# A47 DUALLING – NORTH TUDDENHAM TO EASTON

## FURTHER TRANSPORT SUBMISSIONS in response to Deadline 6 submissions

On behalf of A.C. MEYNELL of the [REDACTED]

17 January 2022

# PROPOSED WOOD LANE JUNCTION

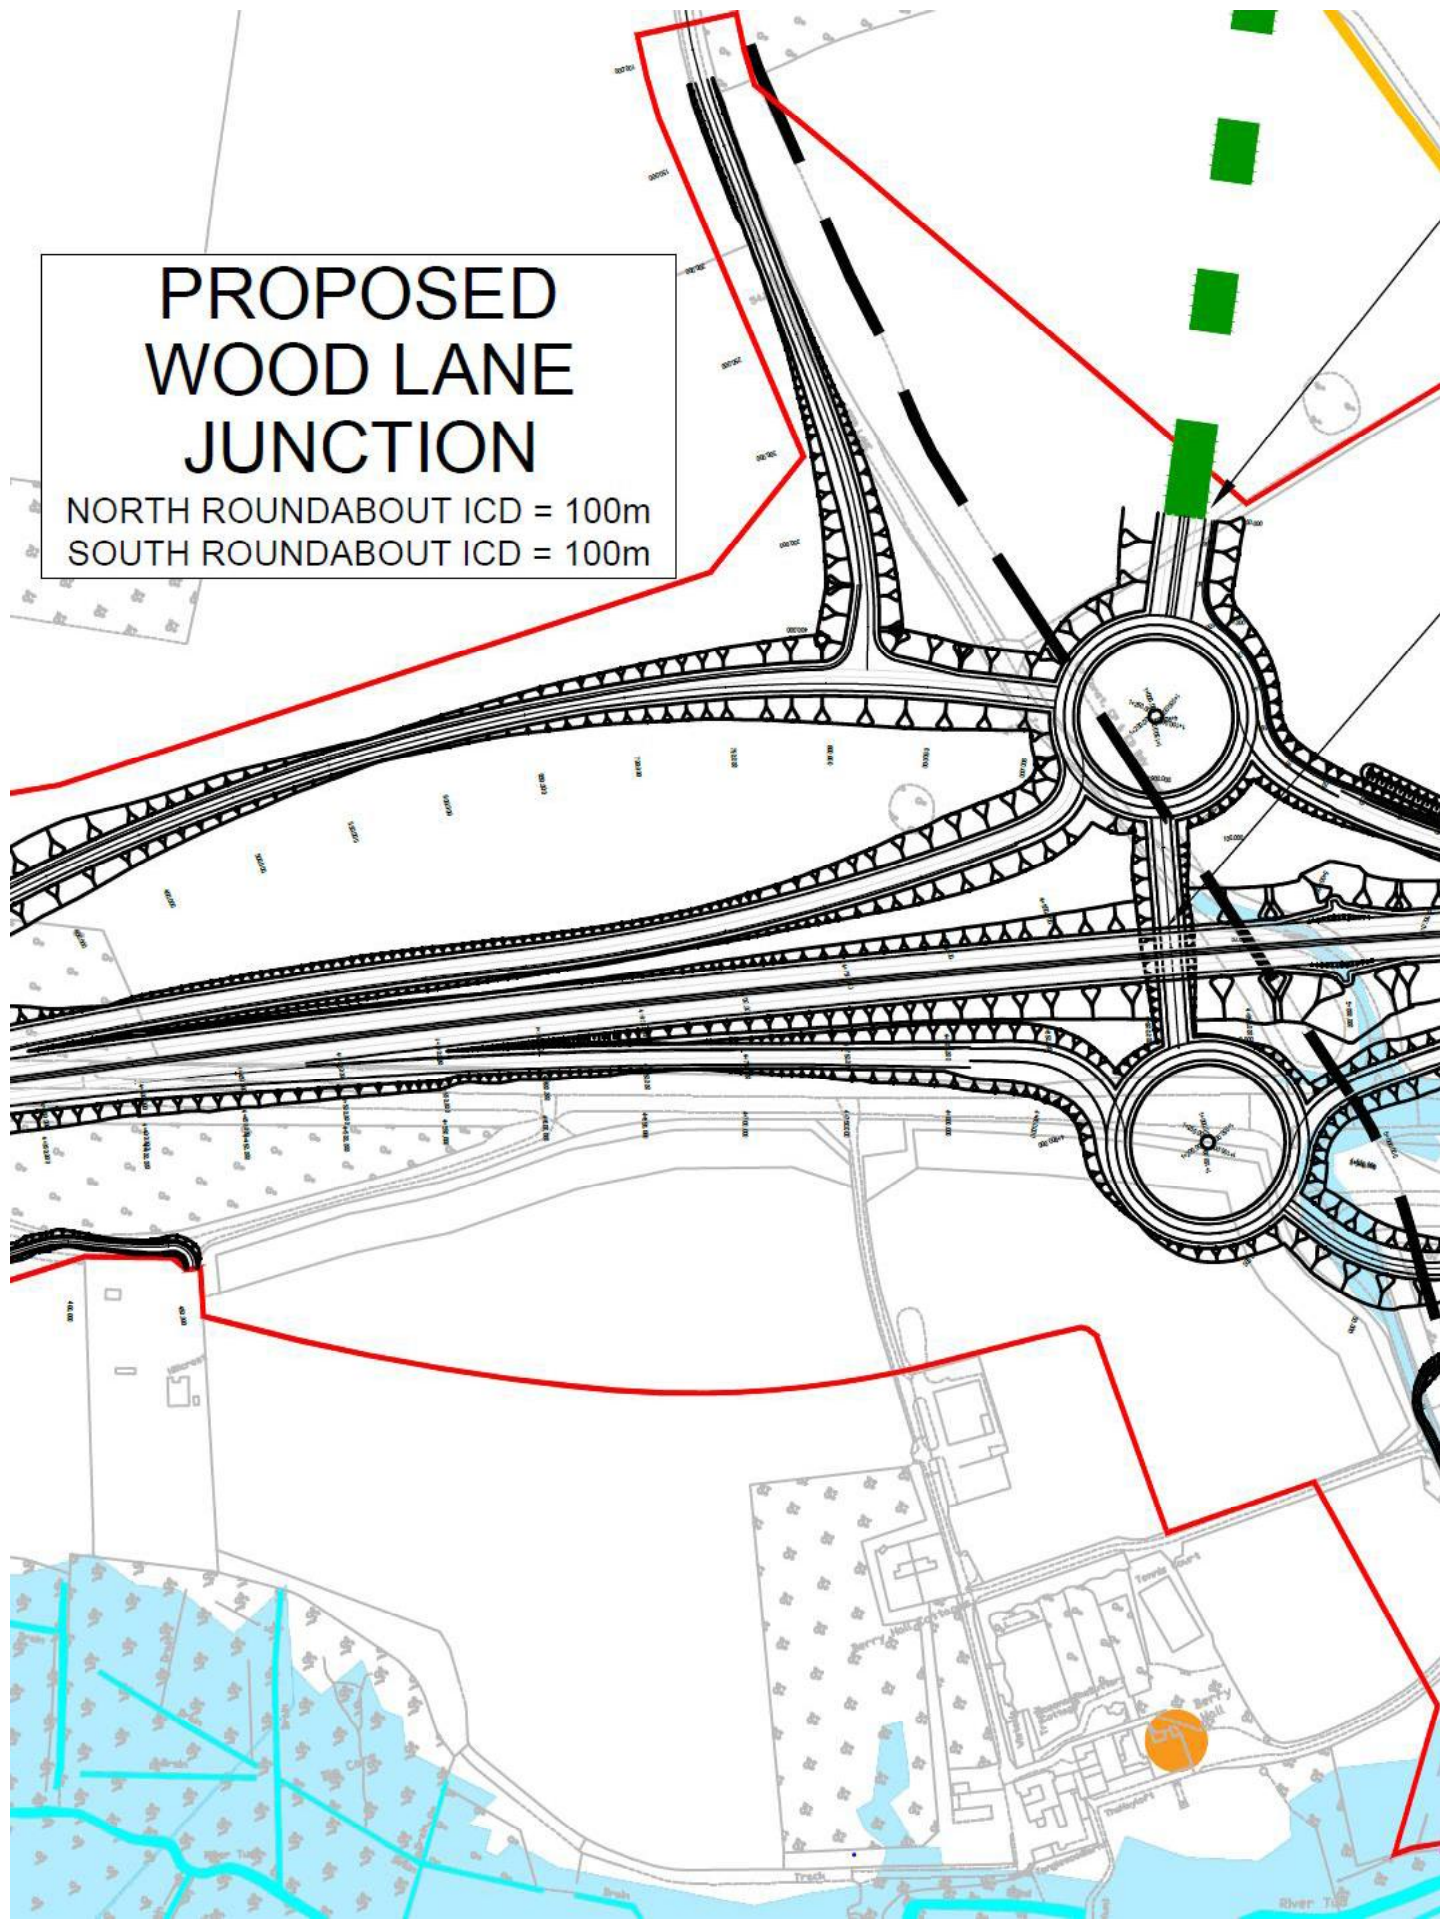
- 4.1 To Q14.3.1 (page 8), NH responds that the two Wood Lane roundabouts which form the dumbbell could be reduced in size in the without NWL scenario, from the currently proposed 100m to 80m diameter, giving a land saving of circa. 0.2 hectares in each case. This equates to 0.4 hectares or 4000m<sup>2</sup>, an area of land NH considers minimal.
- 4.2 Appendix A plan diagram (showing section cutlines) gives a very good portrayal of the comparison between the existing and NH's proposals for the Wood Lane junction, showing the

- 4.6 NH's limited evidence (page 16) to dismiss the option of (at least) reducing the southern roundabout to 80m in the with and/or without NWL scenarios, appears to be related to impact on weaving lengths, HGV flows, and junction flares. However, NH provides no evidence to support these reasons.

- 4.7 Taking the above matters in consideration the need for 100m diameter roundabouts rather than an 80m versions seems unjustifiable 'future proofing'. At the very minimum the southern roundabout should be reduced to 80m, an amendment which will substantially reduce the impact on the [REDACTED] whilst not materially affecting NH's scheme design.

- 6.1 RPS remains of the view that there are no showstoppers with the [REDACTED] Wood Lane alternative junction designs. Both alternatives will have significantly less detrimental impact on the [REDACTED], and are deliverable. As a very minimum the southern roundabout should be reduced in size from 100m to 80m diameter.
